**CITY OF PORTLAND**  
**STOP WORK ORDER**

October 20, 2004

RE: 263 Cumberland Ave.  
CBL: 026-F-008

FINE ESCAPE LANDING TO GROUND
263 Cumberland Ave

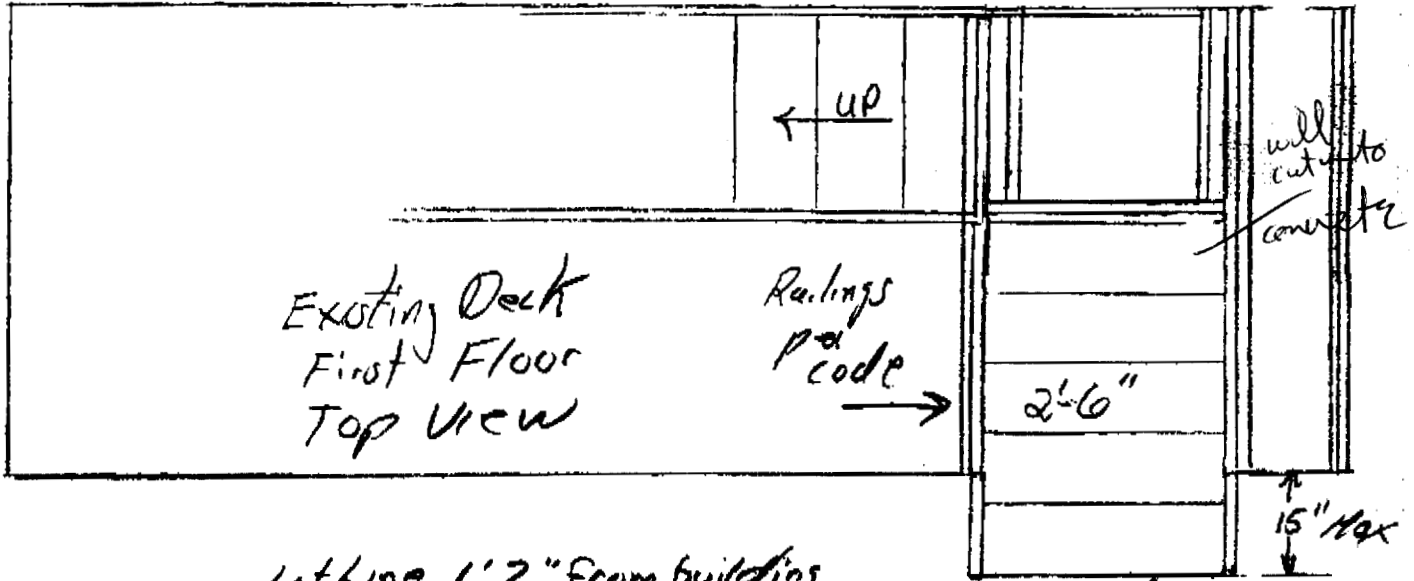
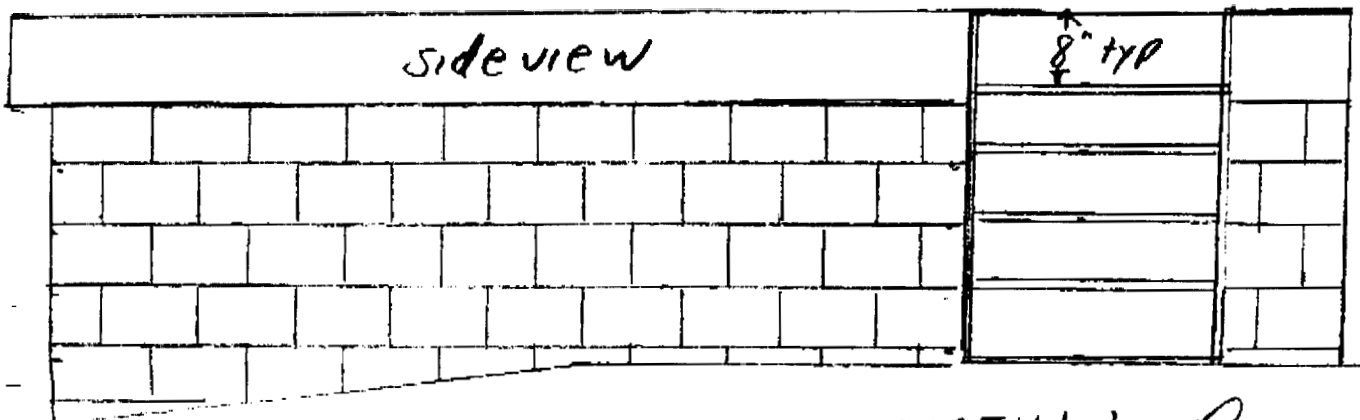
1. The fire escape as configured may not meet the 100 psf. Loading requirement. (Section 1025.3). Confirmed with the contract engineer, Tim Shelley this date.
2. The stair Guard range from 27 inches to 34 inches, less than the required 42 inches. (Section 1022.2.)
3. The landing guards are 38 to 41 inches in height, less than the required 42 inches. (Section 1021.2)
4. The dimensional uniformity of both the treads exceeds the allowances in section 1014.6.2 of the BOCA Code.
5. The stair risers are open, must be closed required in section 1014.6.1.
6. Doors and windows along the configured portions fire escape are not protected as required in section 1025.3.2. and 2406.2.8.
7. The fire escape stairs do not land to the ground. (Section 1006.3)
